SEPA Environmental Checklist
Mercer Island Center for the Arts

Attachment Q
Response to Public Comments Received

MERCER ISLAND CENTER FOR THE ARTS

Responses to Citizen’s Questions to the SEPA Checklist Submission

MERCER ISLAND CENTER FOR THE ARTS CONCEPTUAL MITIGATION PLAN

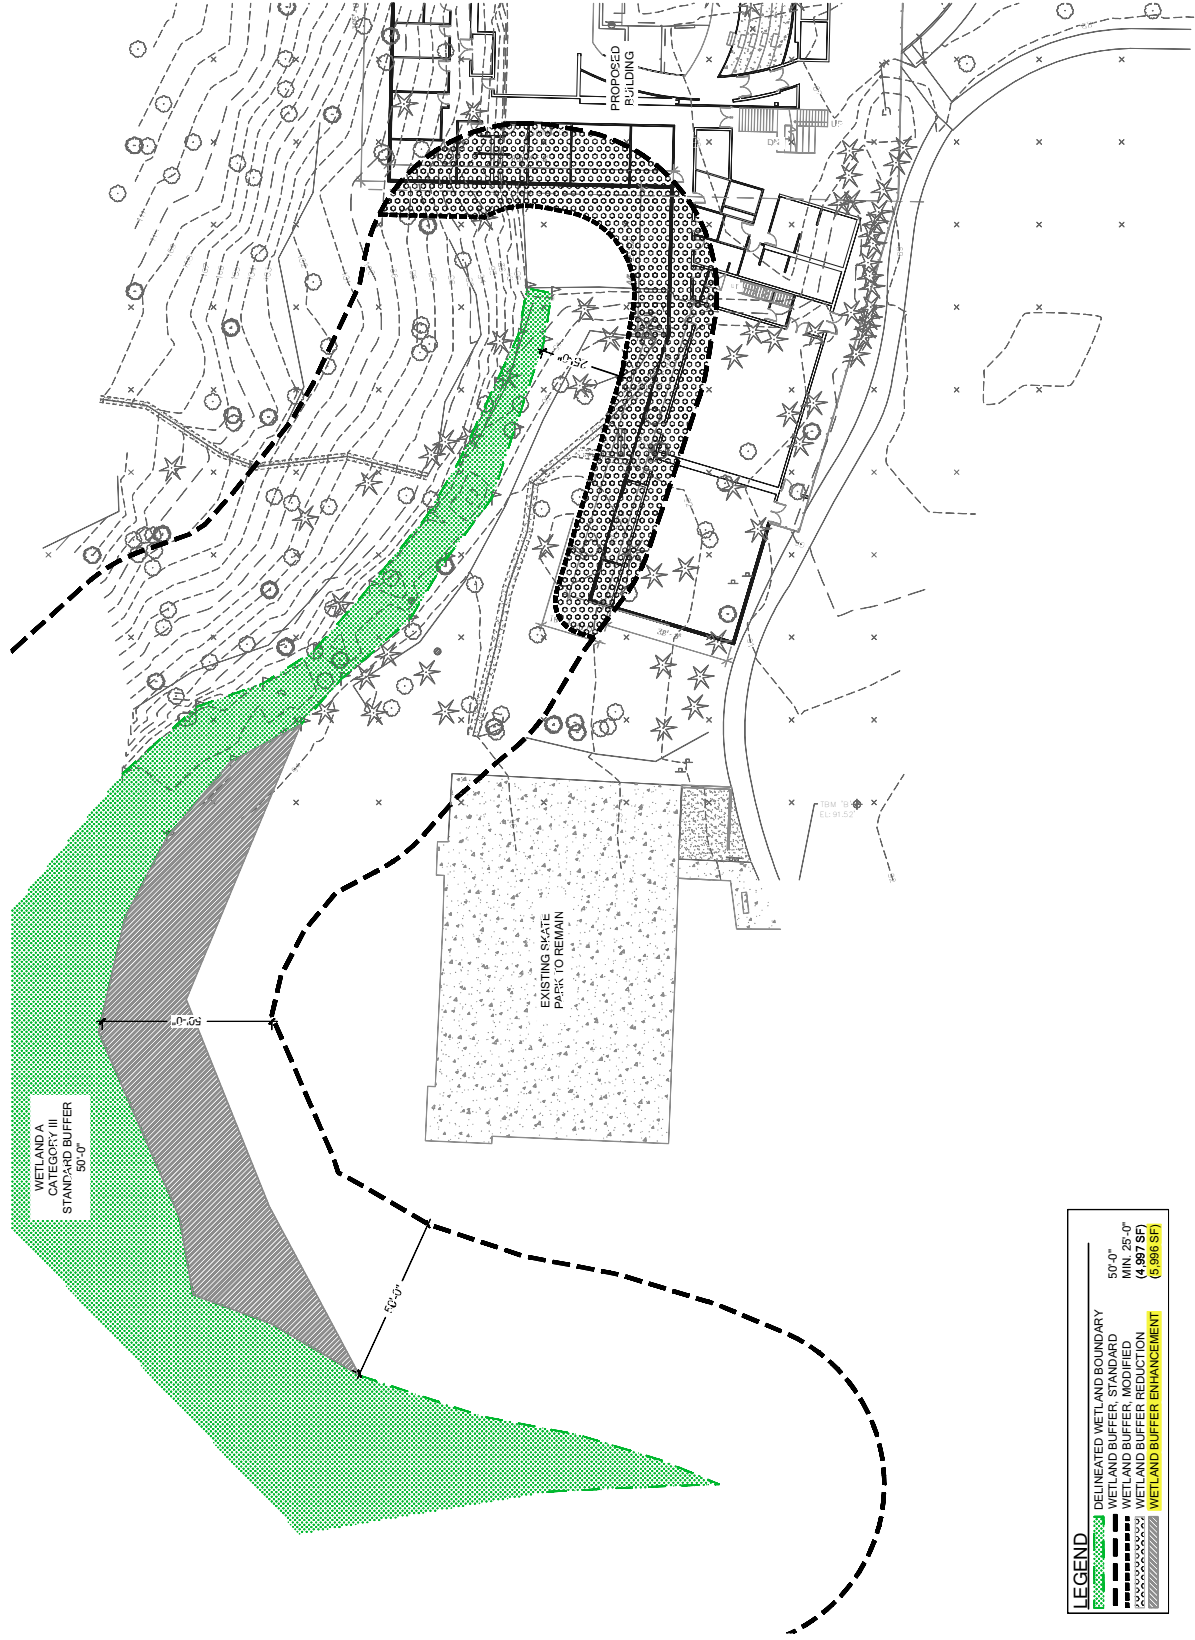
Is there a critical area determination? This is required in order to reduce the buffer zone.

By what authority is the buffer reduced? What is the mitigation?

with mitigation that results in no net loss of wetland and buffer functions. MICA proposes to reduce the standard 50 foot buffer to the code allowed minimum 25-foot buffer in a limited area, which would be a total of 5,746 sf of buffer reduction. The Watershed Company has prepared a mitigation plan that will restore ecological function to 11,362 sf of degraded area within the reduced buffer. This includes an area of pavement removal and restoration with amended soils and native trees, shrubs and ground cover. Other areas of degraded forested buffers will be enhanced with planting of native species. The net effect will be a major improvement to the ecological function and aesthetics of a long-degraded habitat. The mitigation plan is subject to City approval.

A complete description of site conditions and the proposed mitigation plan can be found in Attachment J, Critical Area Study.

Generalized Subsurface Cross Section A-A'

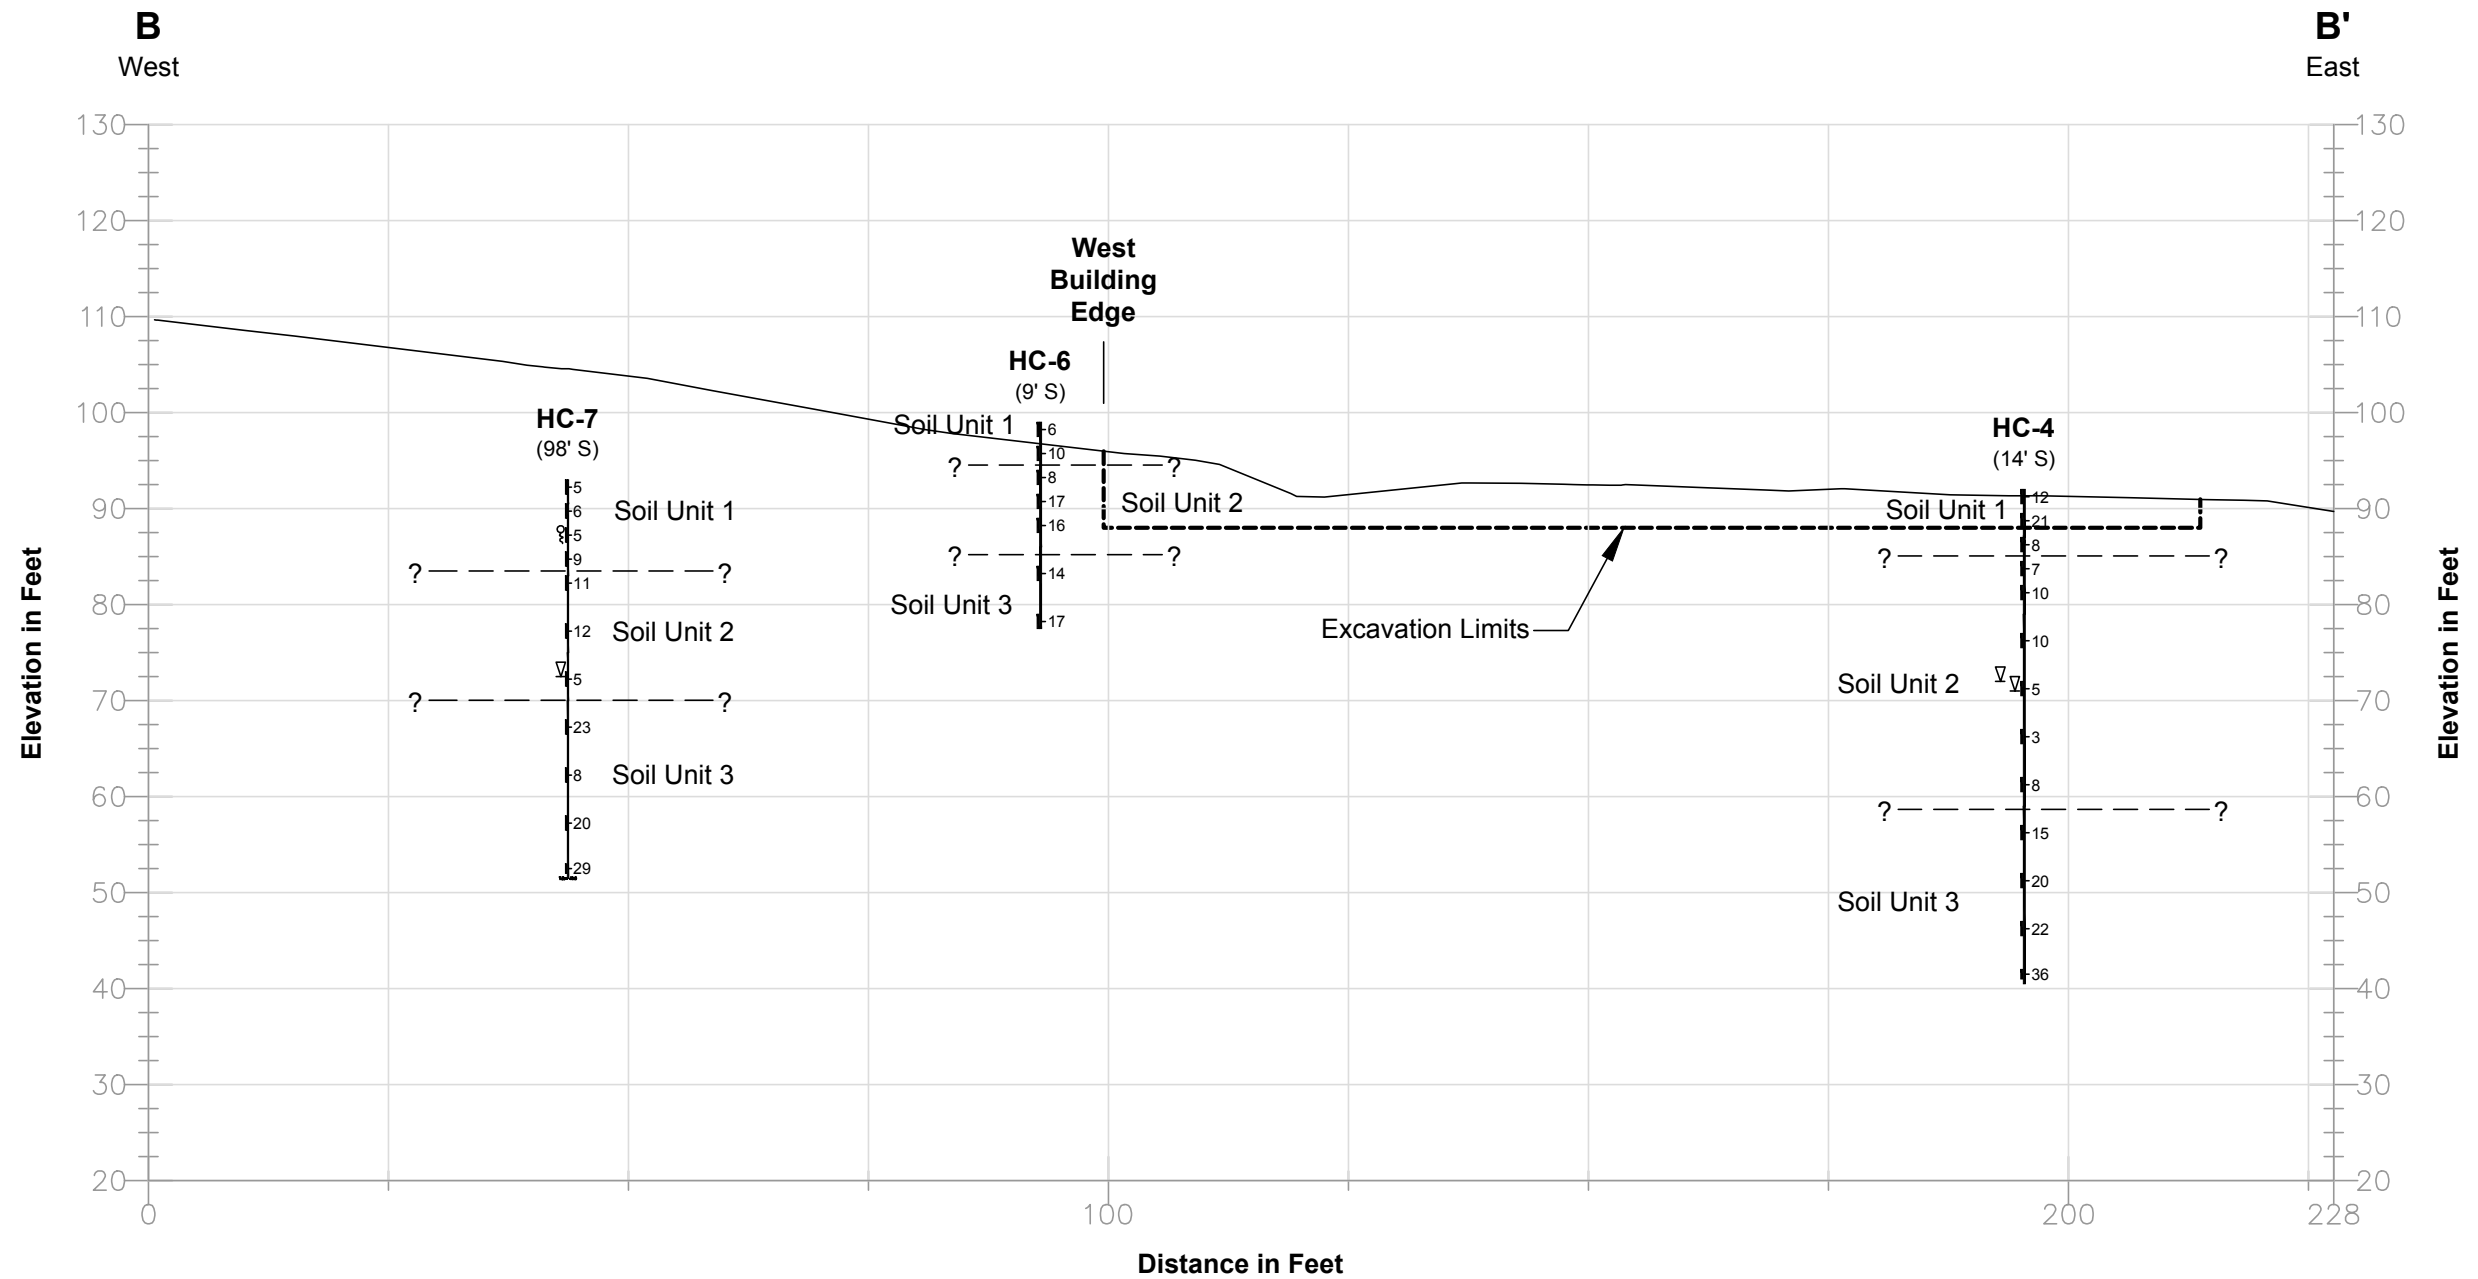
Why isn't this site considered a steep slope?

Is the Mercerdale site safe, given that landslides could put people at risk?

A cross section through the site shows a relatively level condition near the proposed building, rising into the hillside to the west. The portion of the slope that was surveyed, including the lease area, has average gradients of about 5 to 22 percent. Because the City of Mercer Island defines critical slopes as 40% or higher (MICC 19.16.10), the site is not within a critical slope area. The hill rises further west, outside of the site boundary. The eastern portion of the site was filled approximately 48 years ago (Shannon & Wilson 1985). A school was planned for the site, but not built.

MICA’s geotechnical consultants, Hart Crowser, ran several stability analyses for the hill to the west of the MICA site. Based on their surface and subsurface investigations it is their opinion that a landslide hazard does not exist on the MICA site. To reach that conclusion, Hart Crowser analyzed several potential failure modes. In each case the safety factor of the existing soil conditions were sufficiently high that slope failure was deemed unlikely to occur. For further information, see Attachment G, Slope Stability Review.
